Objection Petition in respect of 3 Selsey Avenue, Bognor Regis
Planning Application Reference AW/43/12

Planning Application Reference AW/43/12/ - 3 Selsey Avenue, Bognor Regis

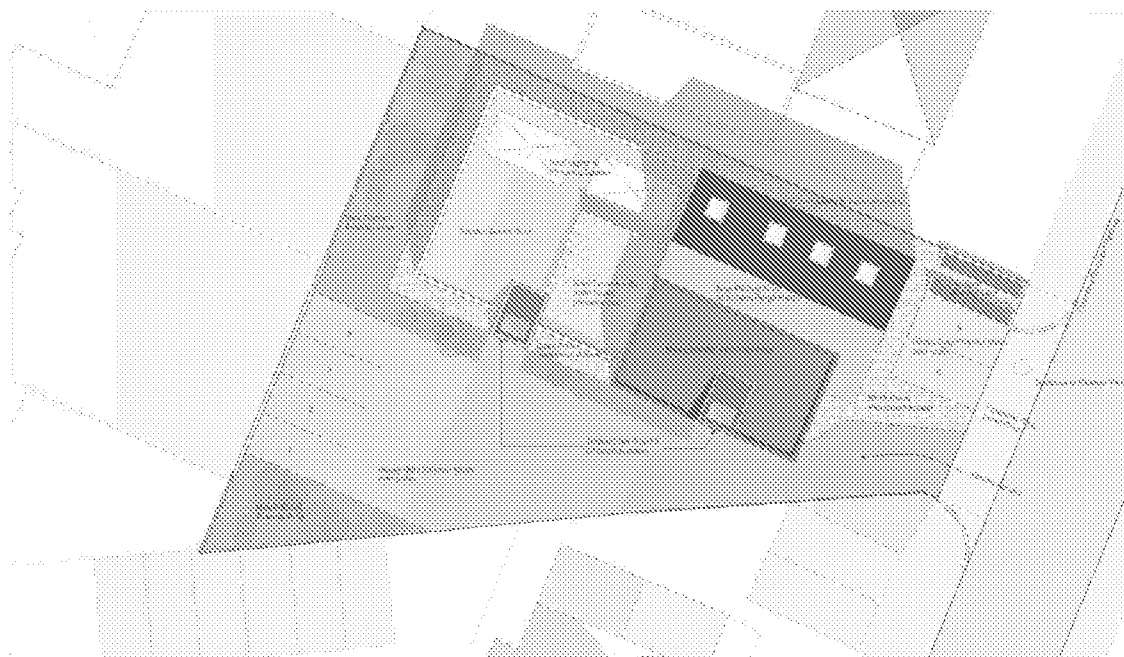
- **Parking** - The amount of off-street parking is unacceptable. This development could mean between 10 and 18 additional cars, not to mention visitors with only 6 off-street parking spaces. Other recent smaller developments in Selsey Avenue have provided one off-street space per unit to allow the existing street scene to remain unchanged as much as possible.

- **Bins** – The location and amount of bins at the front of the property is unacceptable. 14 bins will be unsightly and smelly and will attract vermin. What will happen with these bins on bin day? Will the bin men take the bins and put them back? This doesn't normally happen as they are left on the path. Who will be responsible for making sure 7 (14 on recycling weeks) bins are put back and not left blocking the path? And what of all these additional cars parked on the road; it will only take 2 inconsiderately parked vehicles to block access for bin collection.
- **Trees** – Again, the removal of the tree will set precedence in the Avenue. Selsey Avenue is a mature; tree lined Avenue and is visually pleasing to residents and visitors. Removal of a healthy tree is unnecessary.
